**Consultation Response from KC,  
Lead Local Flood Authority**

**2023/93082 Land Adjacent, 60, Northgate, Cleckheaton, BD19 3NB**

**Discharge of conditions 3-13, 22, 23 and 25 of previous permission 2022/91730 for demolition of former dairy/snooker centre/storage and erection of 9 light industrial units**

**Date Responded: 24/11/2023.**

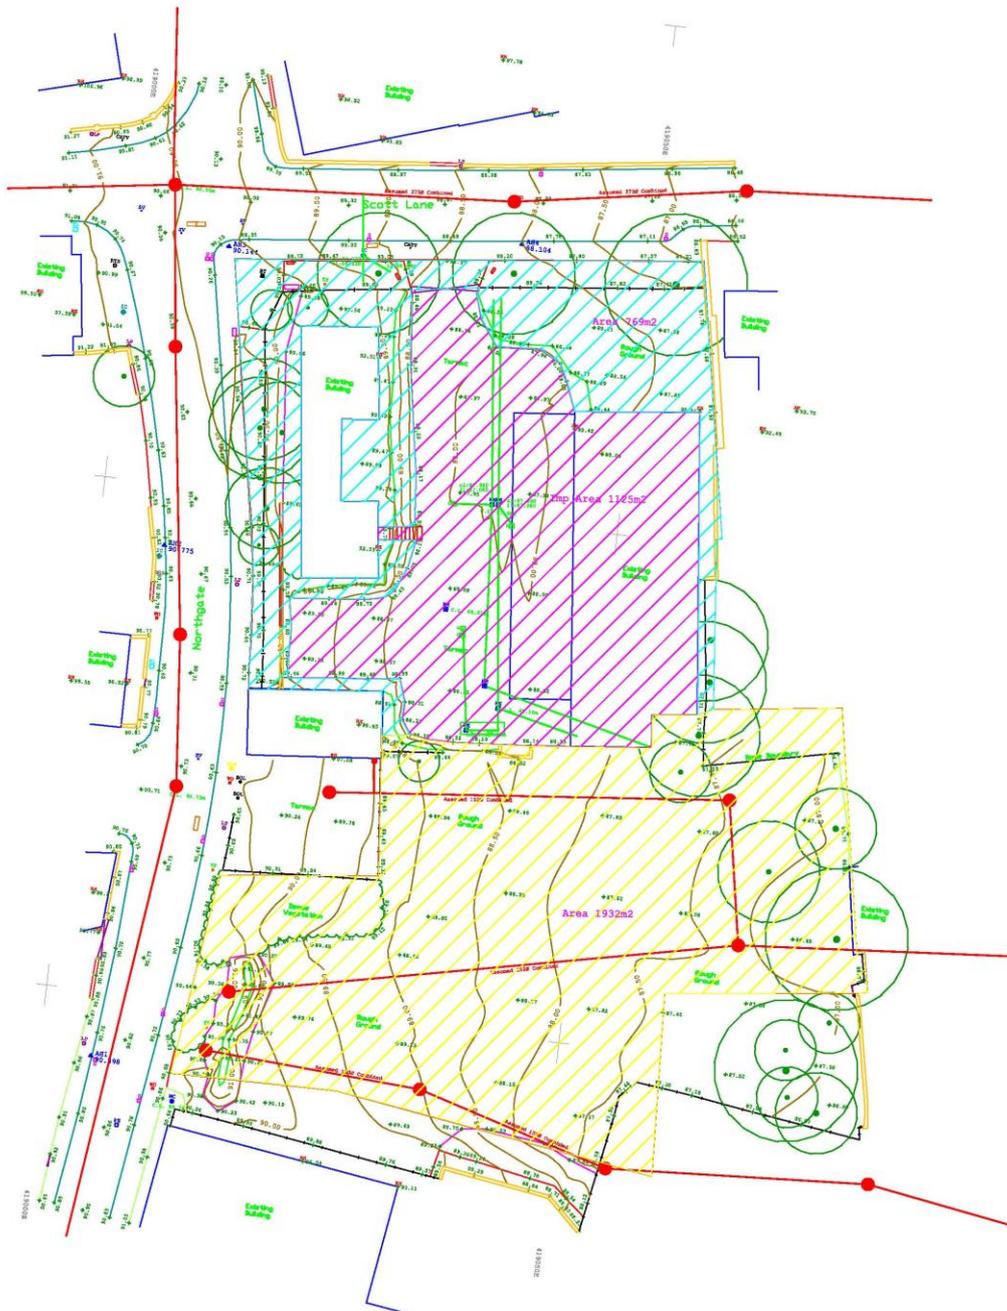
The planning permission Decision Notice states that the drainage from the road should pass through an oil separator without roof water as this can flush out contaminants within the separator during periods of heavy rainfall. Therefore the road gullies shown on the Drainage Layout should discharge to a separate piped drain and through the separator prior to connection to the flow control chamber.

The developer should revise the Drainage Layout to address the above issue and re-submit the details. Therefore this condition **cannot be** discharged.
